MONUMENT FIRE DISTRICT
16055 Old Forest Point, Suite #102
Monument, CO 80132
(719) 484-0911
www.monumentfire.org
Proudly serving the Tri-Lakes Region

To: El Paso County Planning and Community Development Department
From: Jonathan Bradley, Fire Marshal
Subject: Monument Glamping II
Date: October 4, 2024

The Monument Fire District has reviewed the Monument Glamping II Site Development Plan dated 8/14/24. Based on our initial review of the site plan for fire apparatus access and emergency egress we have the following comment:

MICAH JEUB
GLAMPING II
SITE DEVELOPMENT PLAN

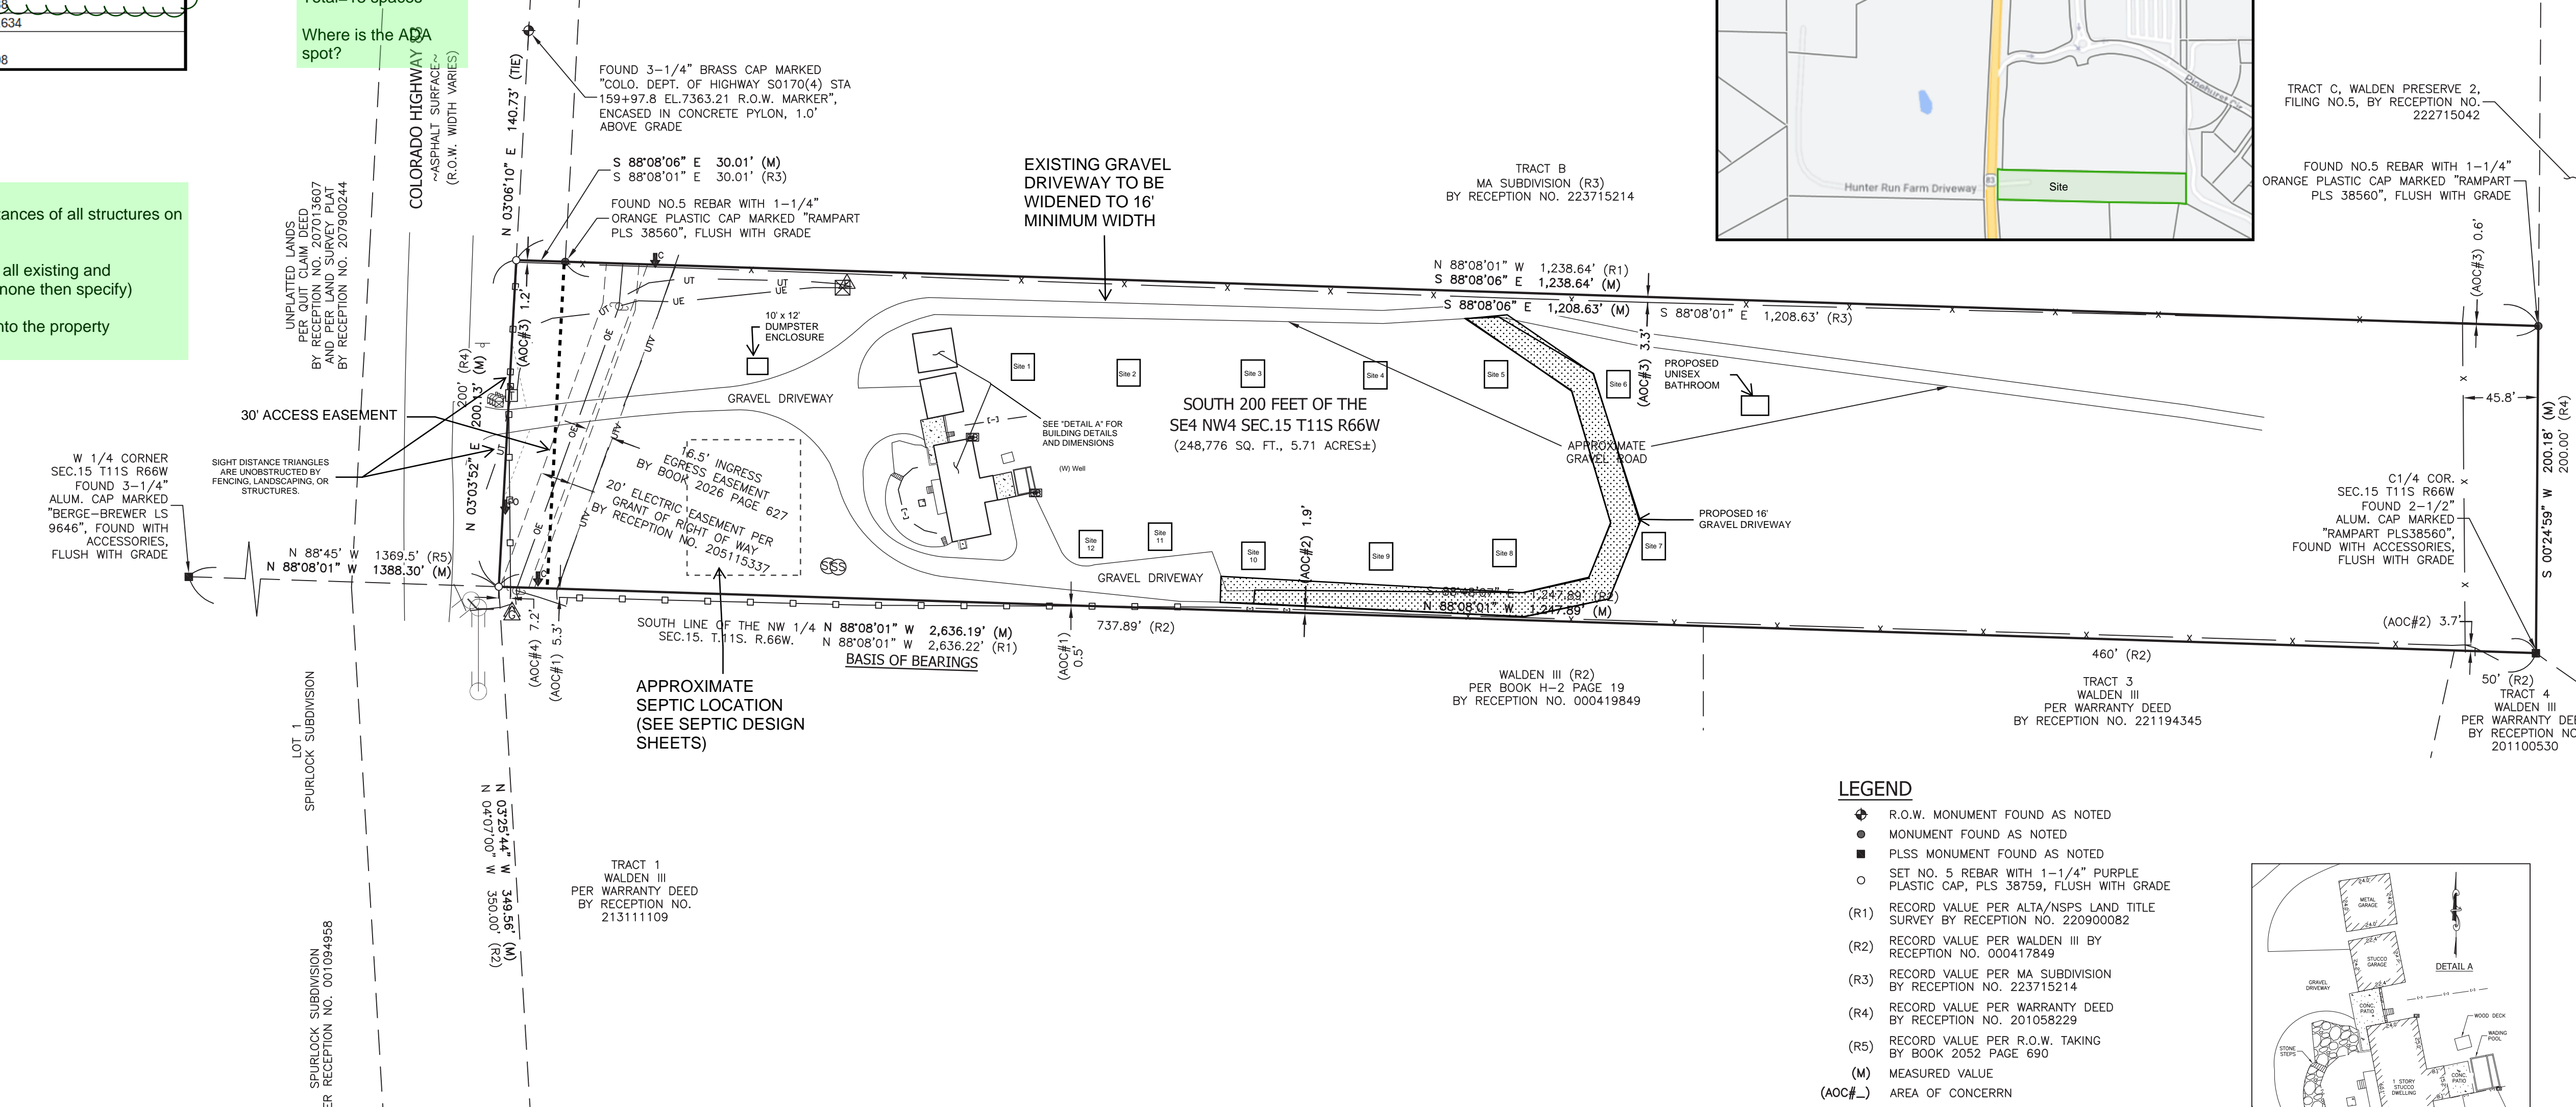
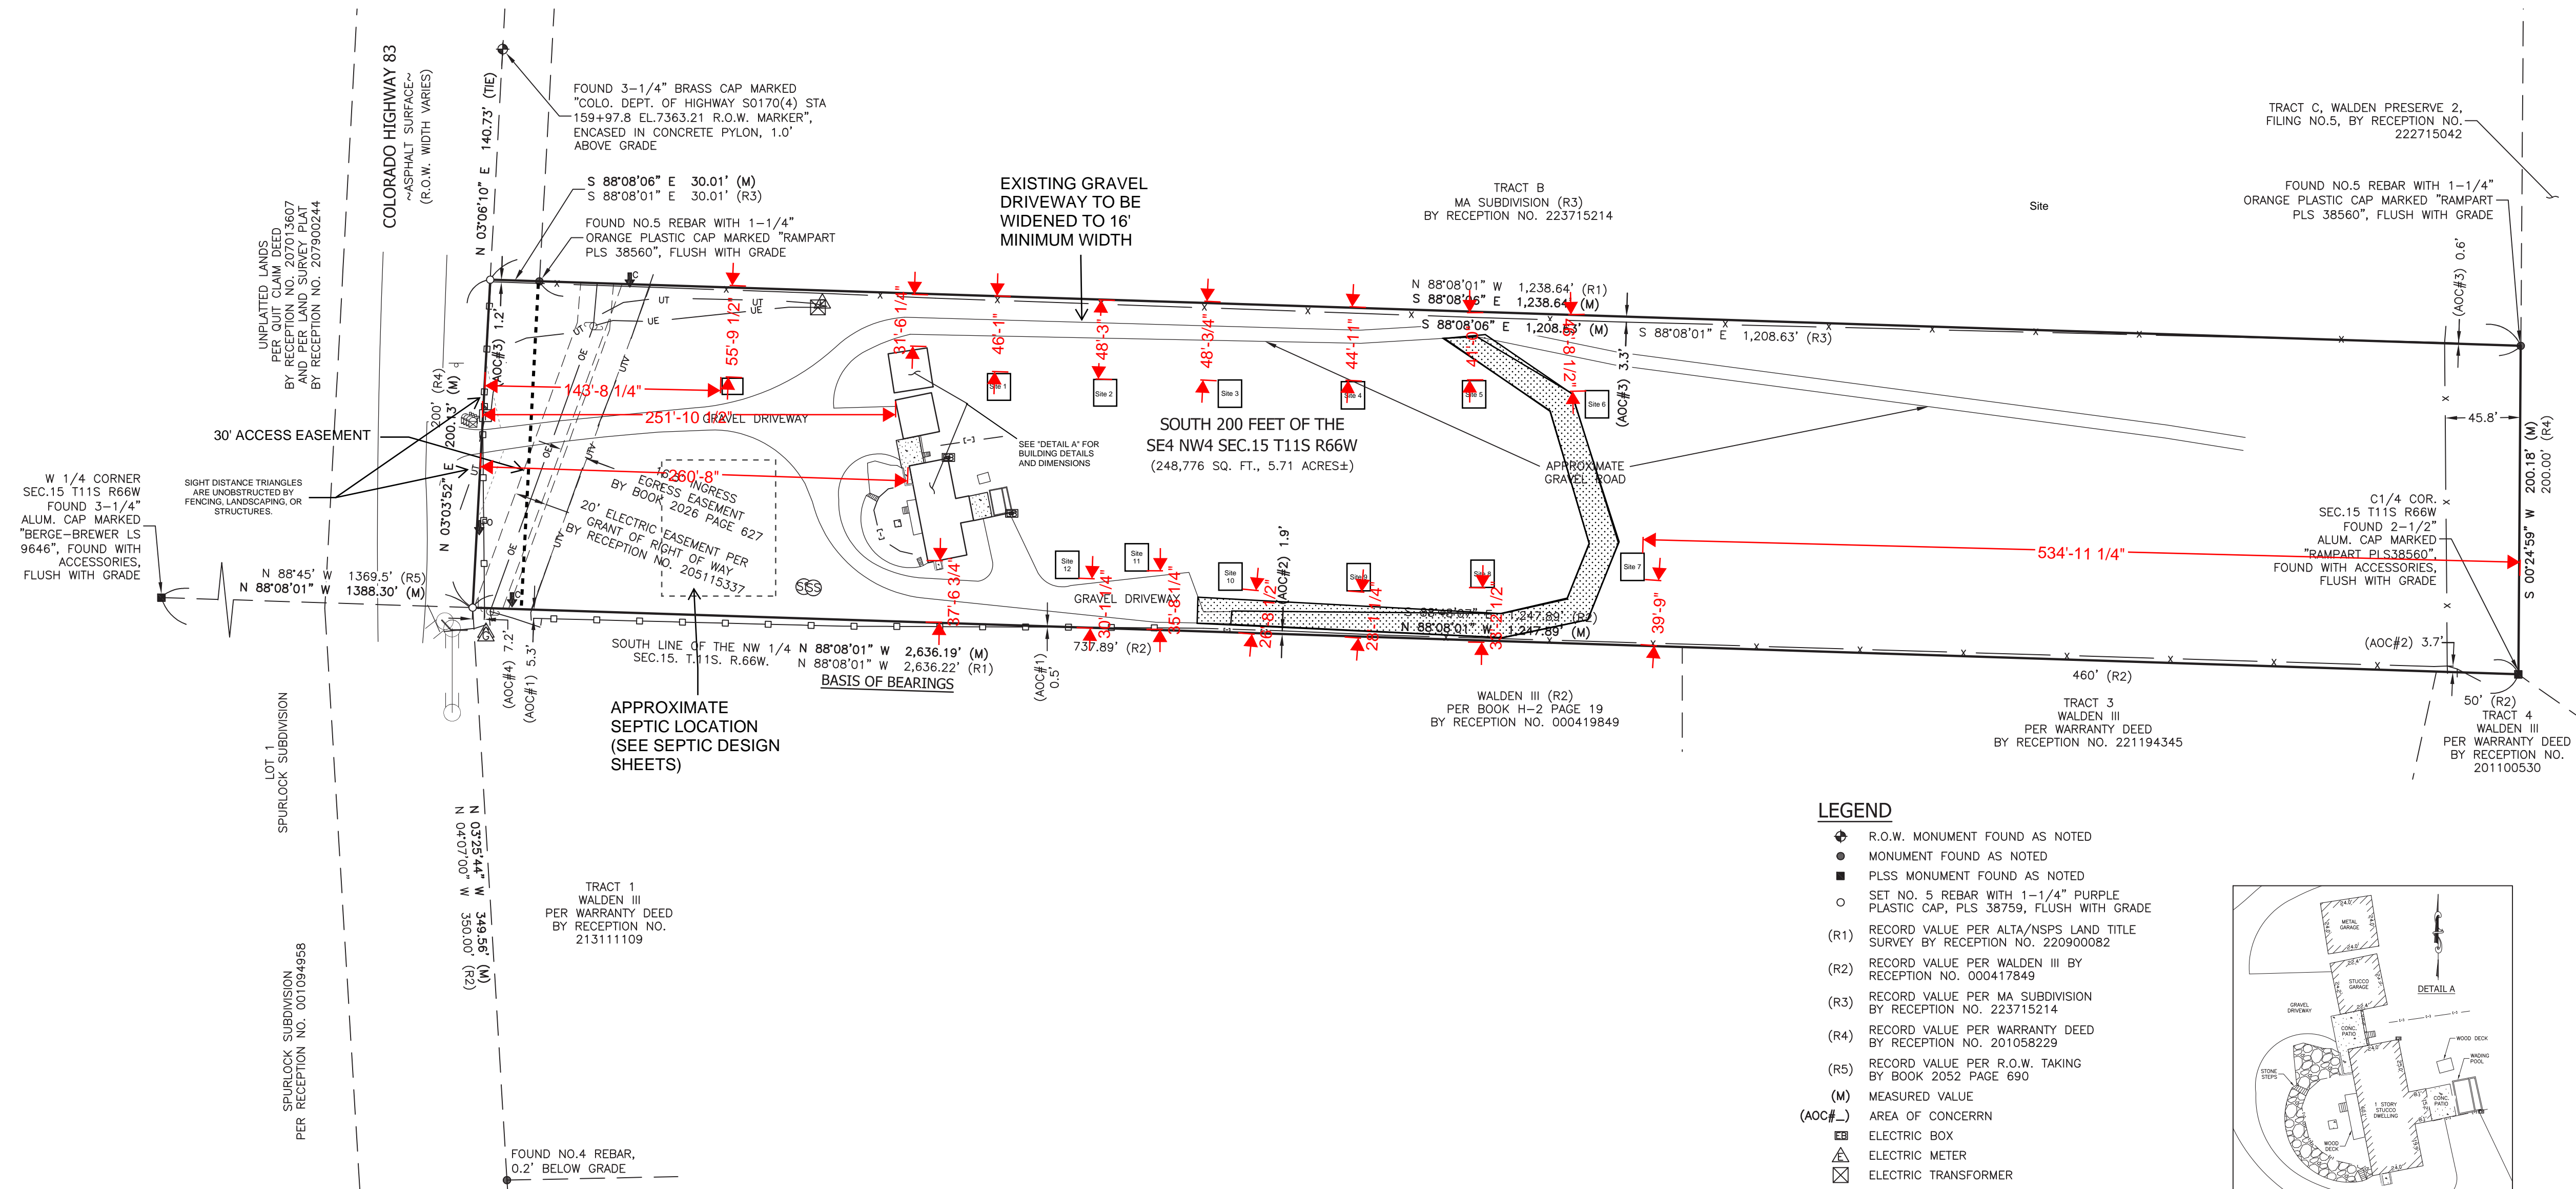
- The fire department requests that the section of the gravel driveway at the far east section of the loop that generally runs north/south have a minimum width of 20' or greater.
